120-160 VALLEY STREET

July 29, 1954

GL 120-160 Valley St.
Proposed New England Tel. & Tel. Co. Garage

**PLOT PLAN**  
**PROPOSED GARAGE AND STOCK ROOM BUILDING**  
 FOR NEW ENGLAND TELEPHONE AND TELEGRAPH CO.  
 AT VALLEY AND ST. JOHN STREETS PORTLAND MAINE  
 JUNE 25, 1954

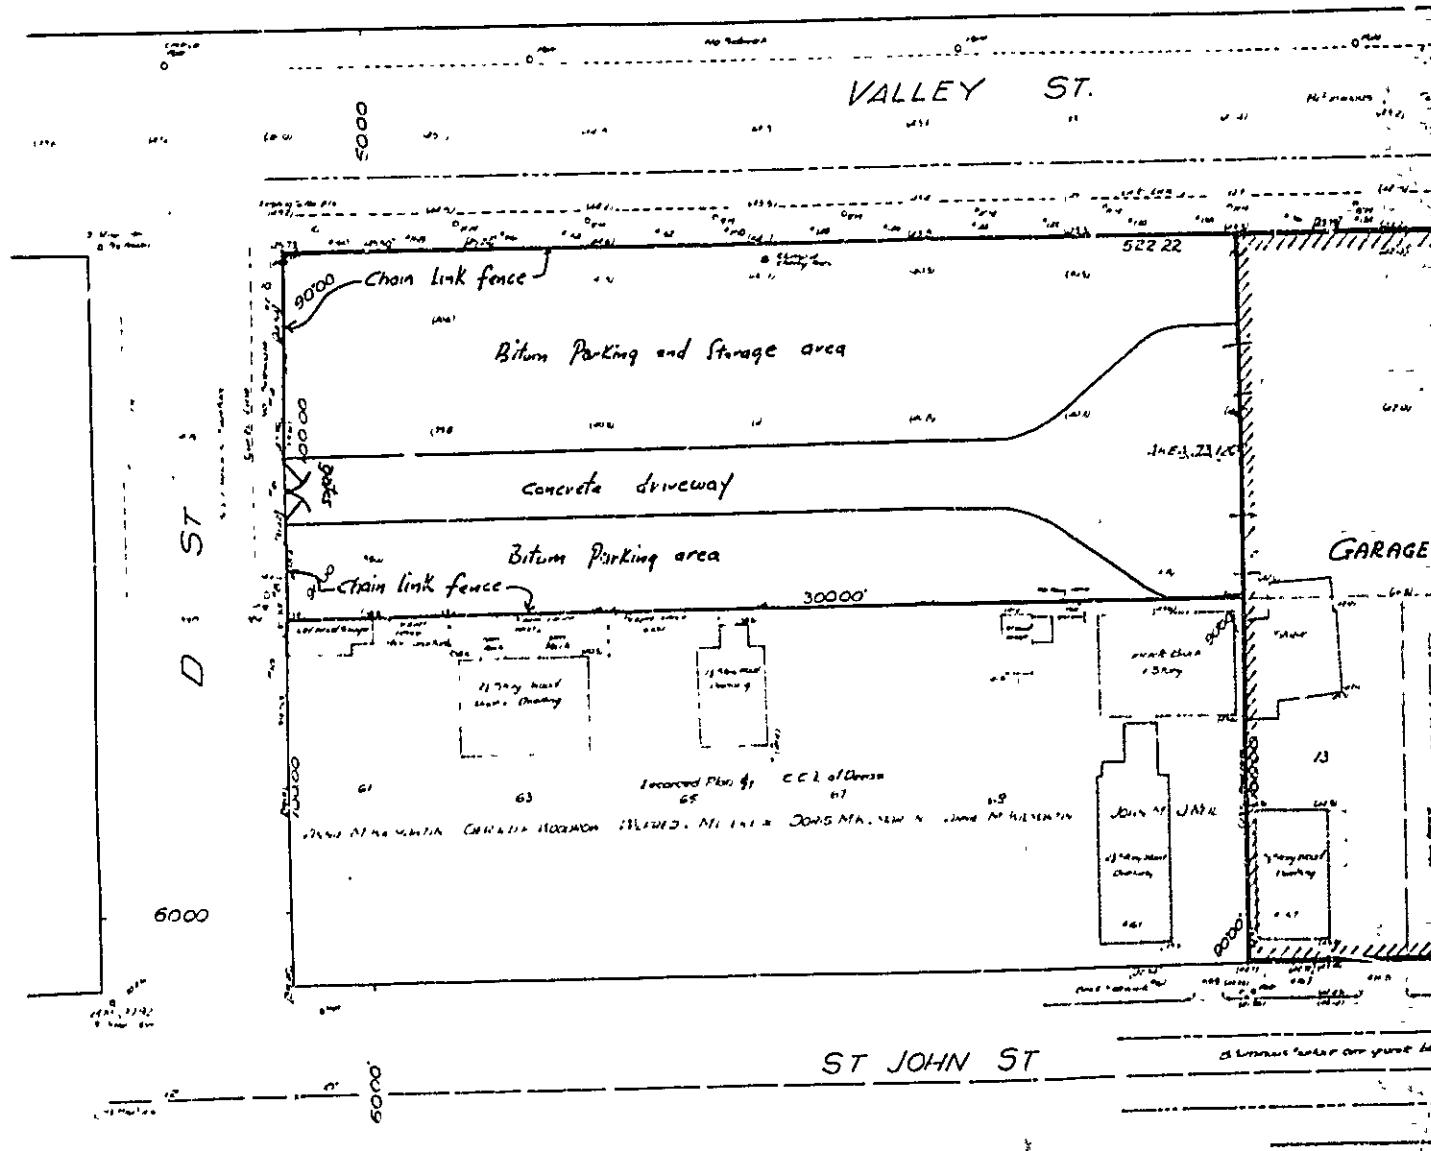
Will you please advise if the City of Portland Building Code requires a door in building walls abutting Public Ways for the safety of people housed within buildings abutting said public ways.

Secondly, if the garage building shown on the enclosed floor plan was built with one exterior wall of the garage abutting Valley Street, would you require a door in said exterior wall.

From our point of view we feel that there are a sufficient number of egress doors from the proposed building but would appreciate your opinions and egress requirements to Valley Street if any.

1. Our Building Code does not require a door in building walls abutting public ways unless that is the only place where suitable means of egress can be provided.
2. The proposed garage, shown on the plan which you sent, would not require a door in the exterior wall along Valley St. This is on the basis that the two swinging doors at either end of each of the garage driveways will be considered to meet the requirements for means of egress if the arrangement of storage of vehicles is as shown on the plan.

P. S. No other features of the plans have been examined or checked.
